Application No: EP/7/21/HH
Site Address: Little Dormers 23 Upper Drive East Preston BN16 1QN
Description of works: New bay/porch skirt roof to front elevation & single storey front extension to provide additional garaging.

OWPC33793

'Little Dormers' 23 Upper Drive, East Preston, is situated within the Angmering on Sea Estate. This is a 'private' estate which is maintained by its residents' association - AOSERA.

Drawing Name
Floor Plans and Roof Plan - Proposed

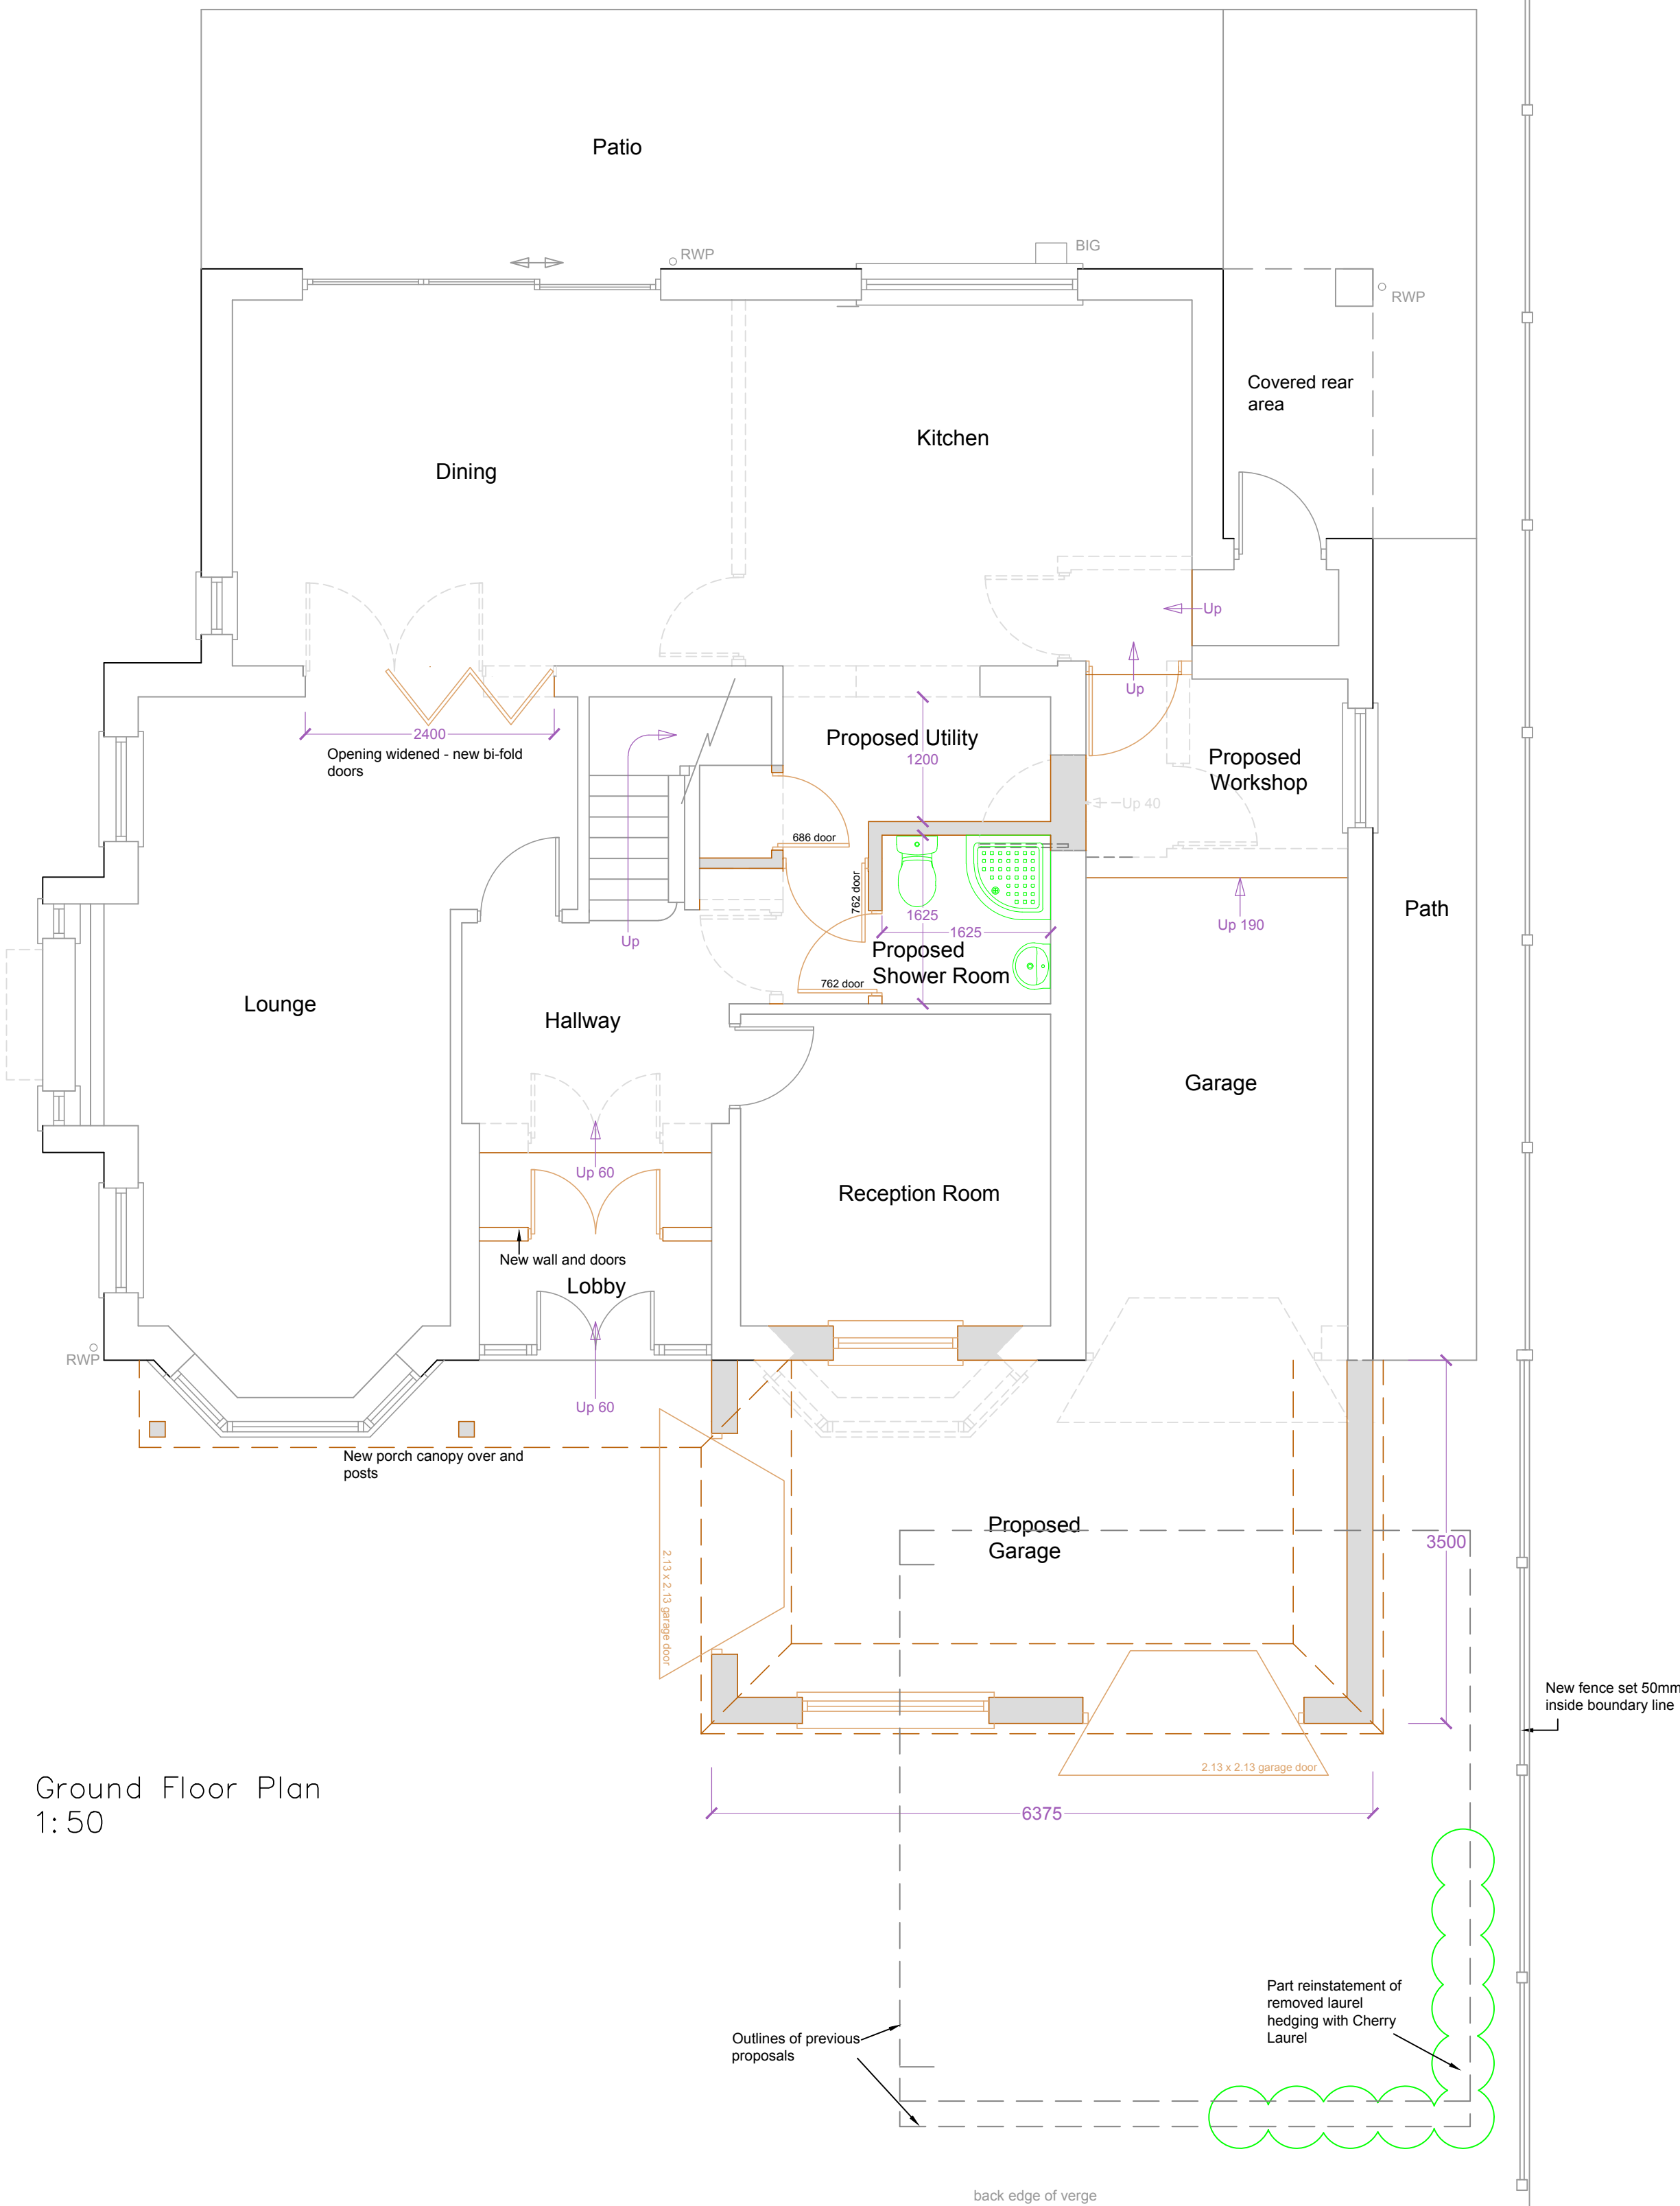
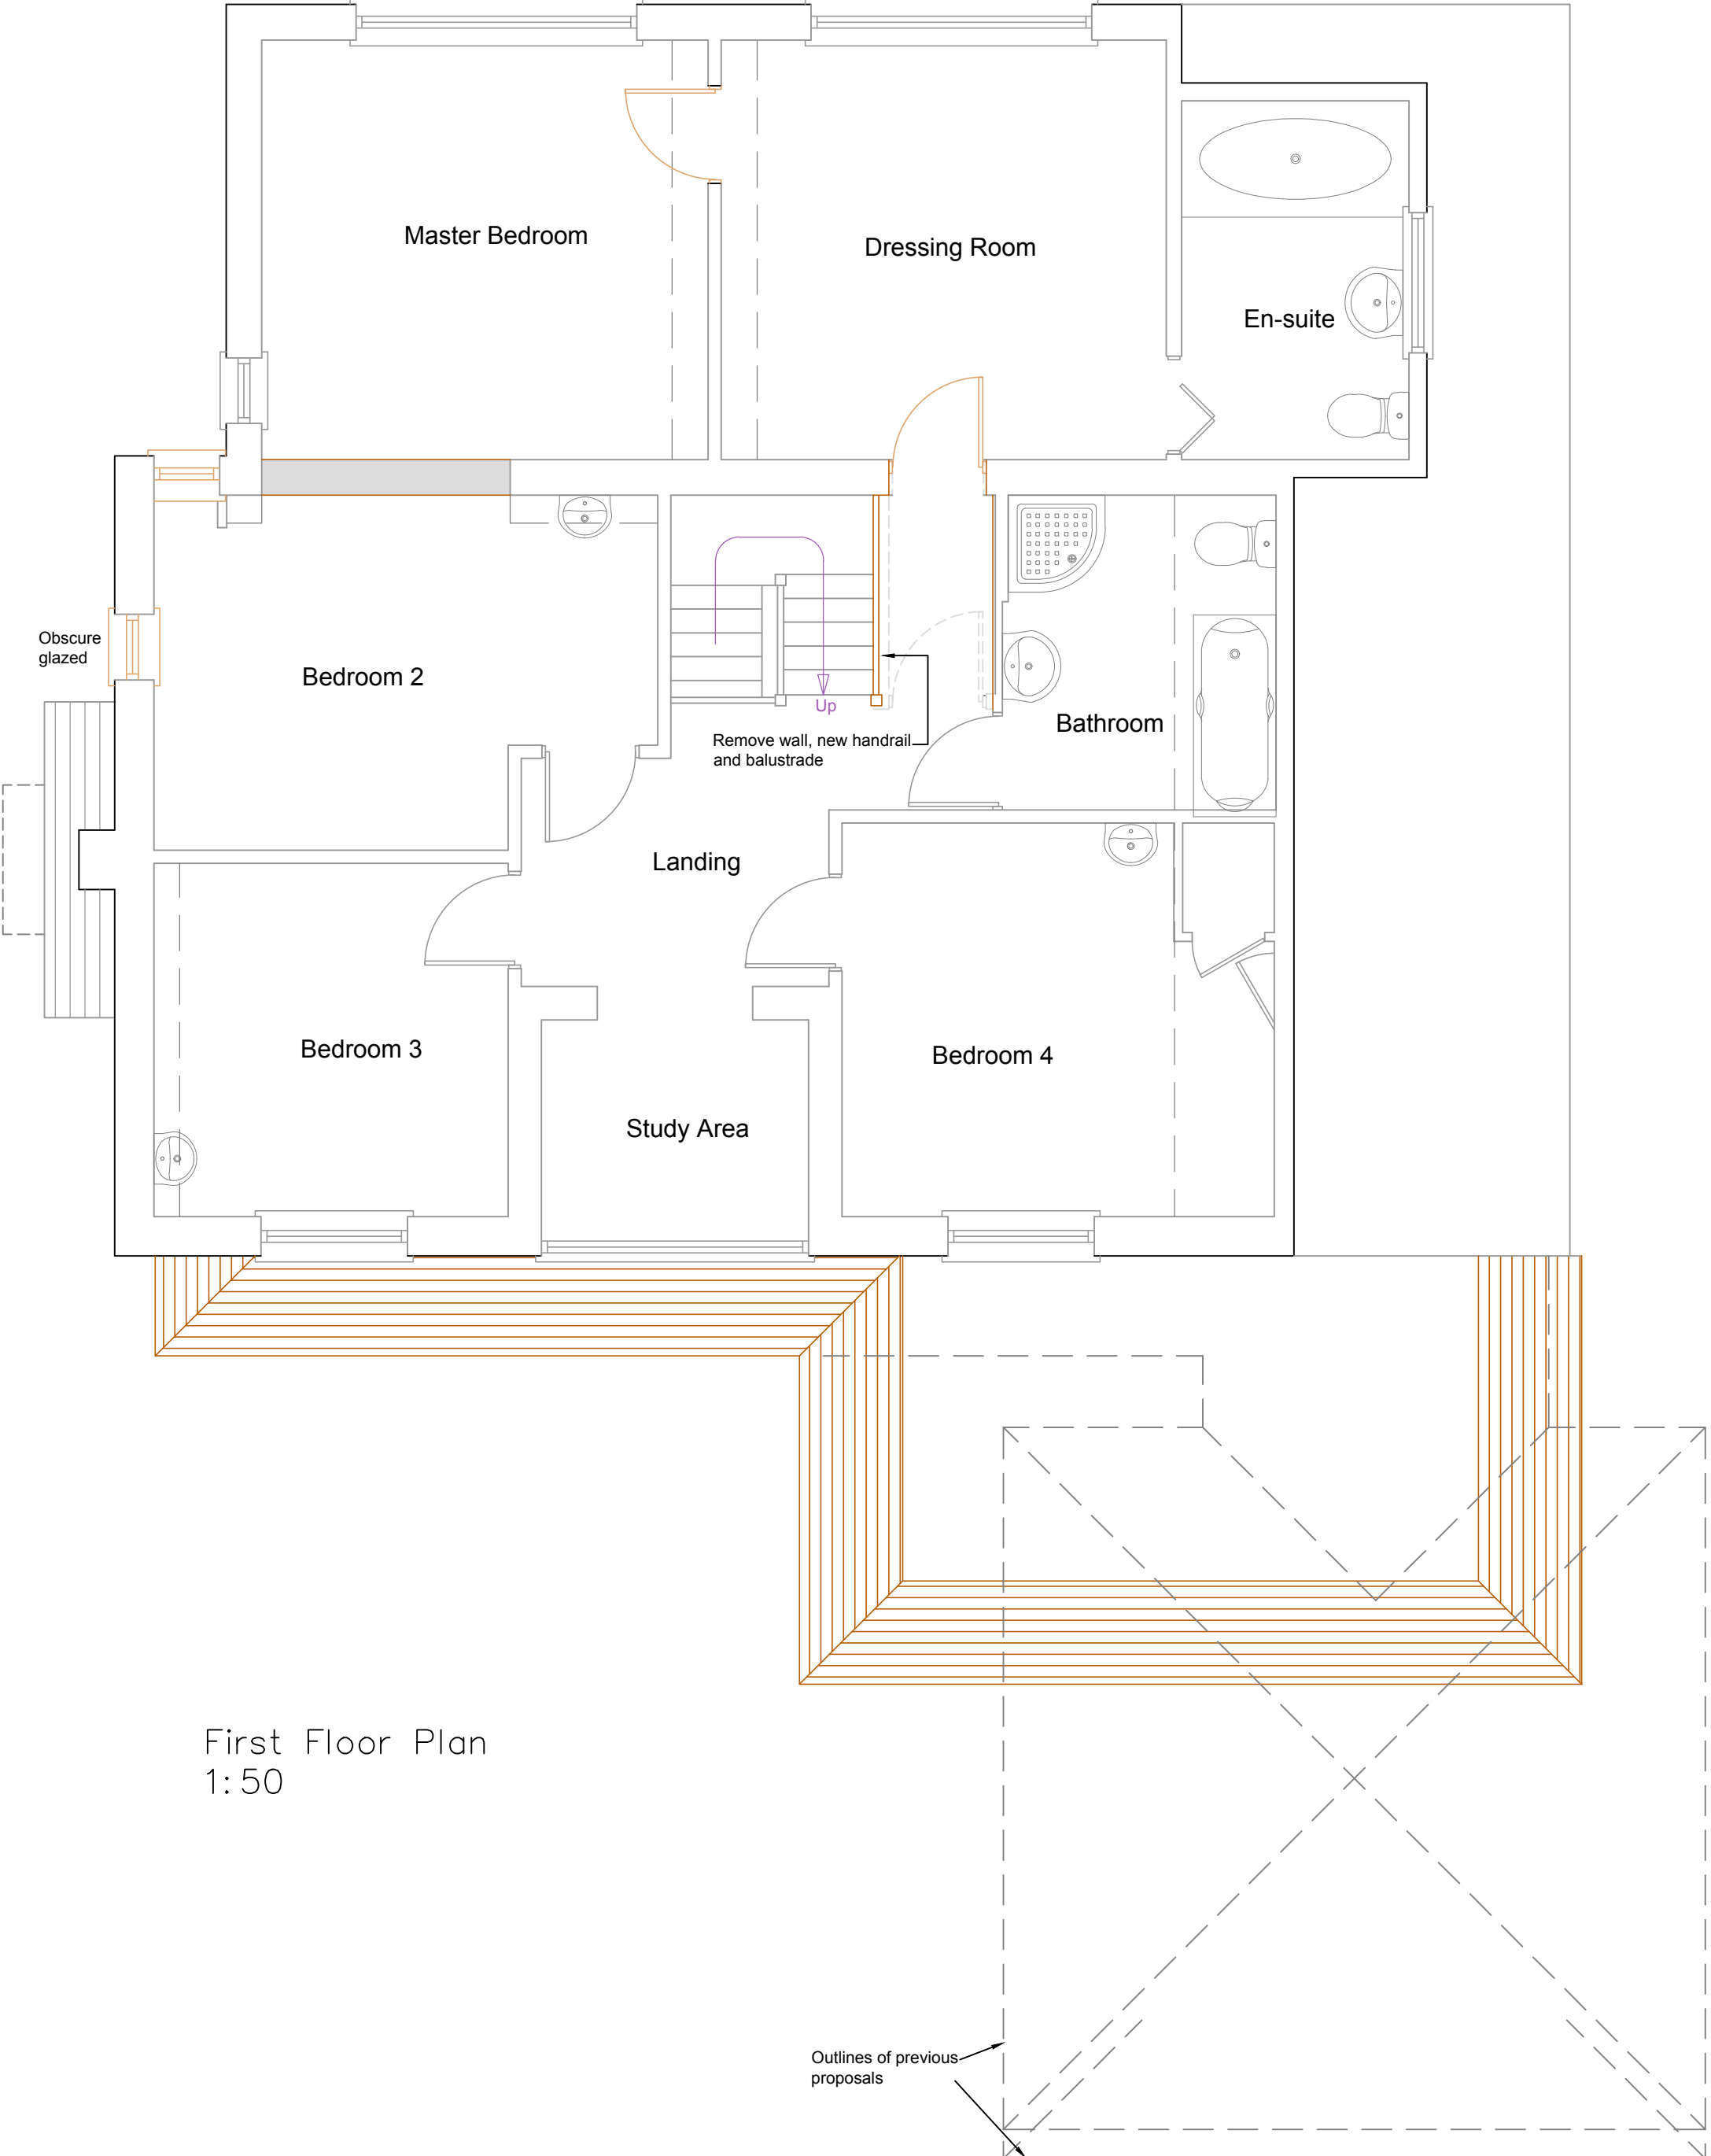
The proposed building line is approximately 1.5m further forward than that of the neighbours at No.25. However, the properties at 21 and 29 are even further forward. The proposed position of the garage means that the 45 degree angle from the closest window of No.25 is not obstructed. Closer observation of this section of Upper Drive reveals that there is no uniformity in the building line.

The new proposal results in a significantly reduced garage; the planned roof is now 3200mm high - previous proposals were 4715mm and 3670mm. The positioning of the garage on the drive will have a reduced impact: the face edge of the proposed garage is 3500mm from the face edge of the existing house and the face edge of the proposed garage is 4650mm from the edge of the verge which is owned by AOSERA. It is worth noting at this point that the entire estate consists of landscaped verges in lieu of pavements.

Drawing Name
Elevations-Proposed

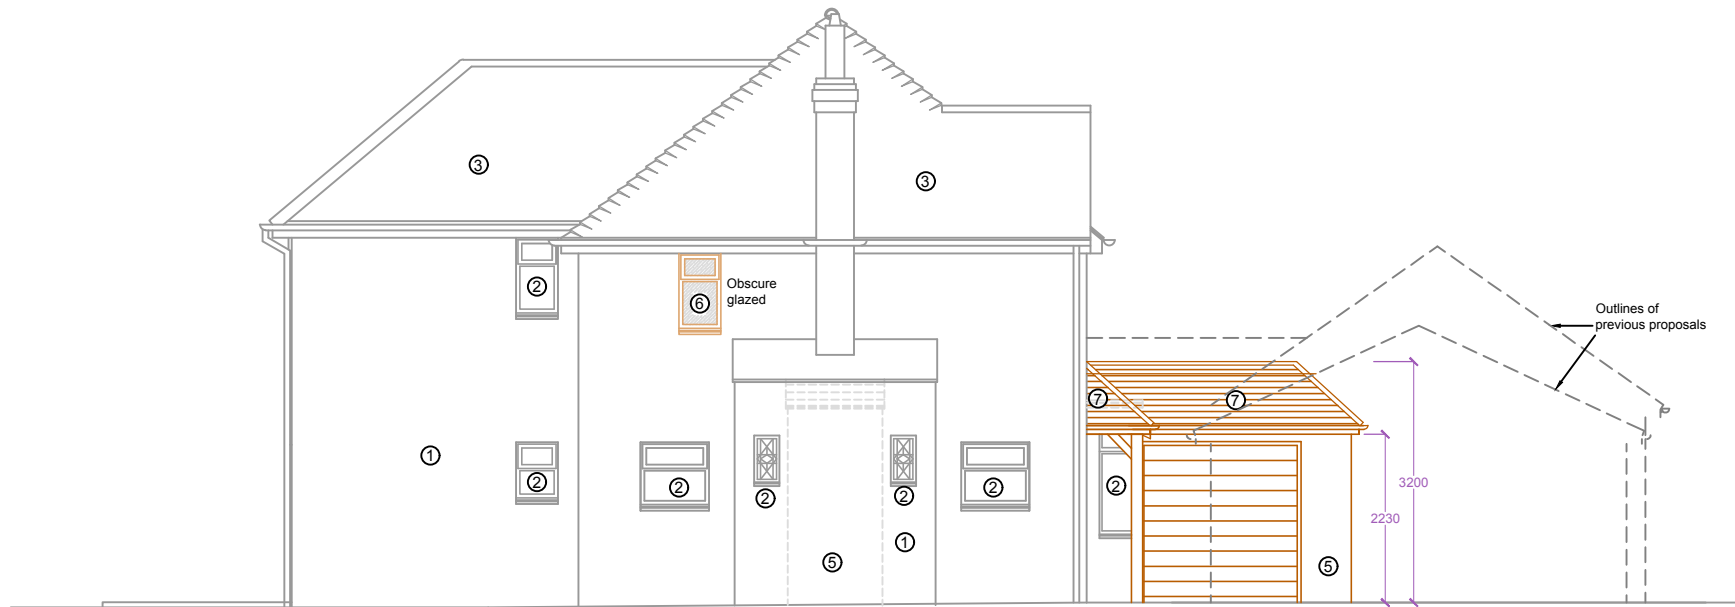
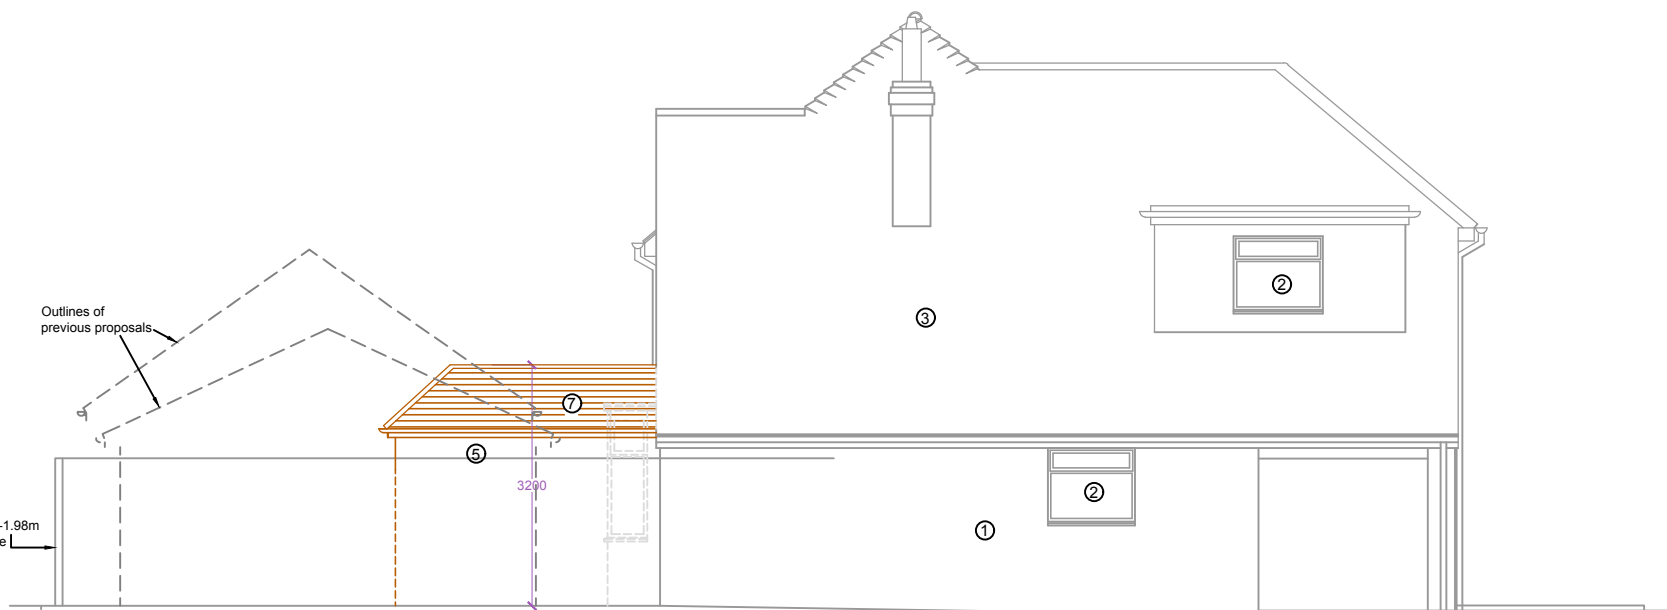
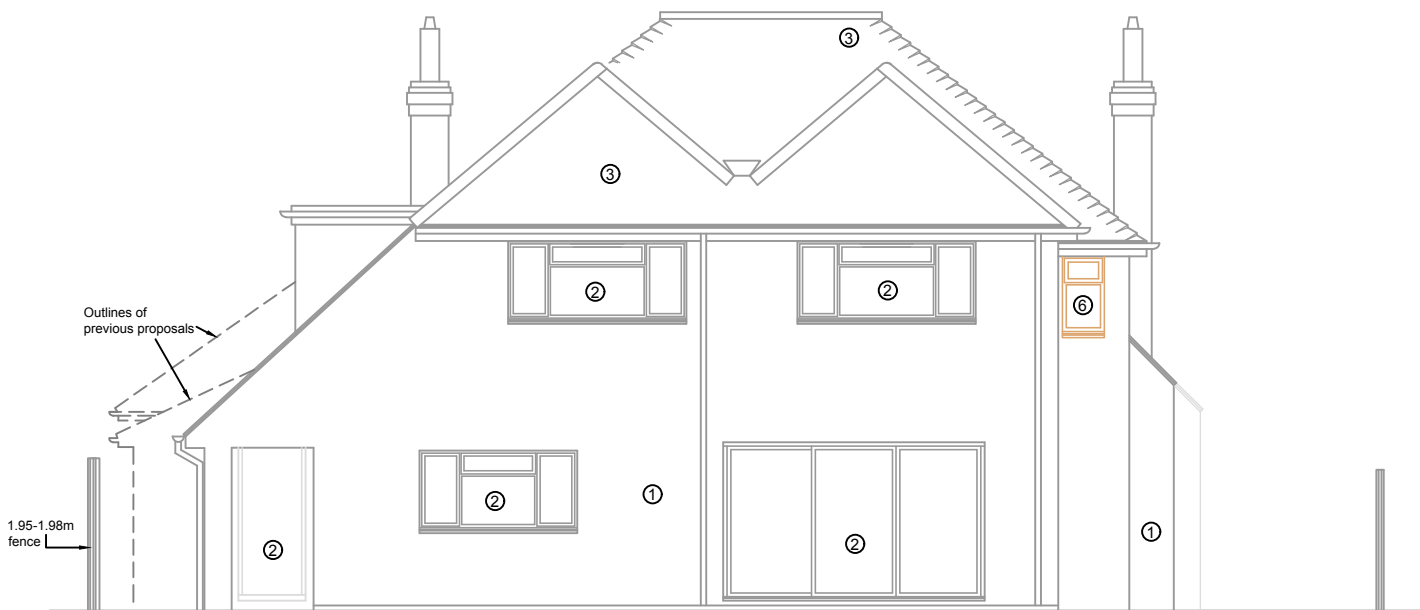
The submitted planning application does not make reference to the intention to install two new windows in the rear of the existing property. The submitted 'proposed elevations' plan reveals that a new window (highlighted in brown) is proposed for the southern elevation and a similar new window (highlighted in brown) to the western elevation. We wish to propose that, if approved, a condition is considered stating that these windows should include obscured glass and be partially non-opening in order to protect the amenity and privacy of the neighbours.
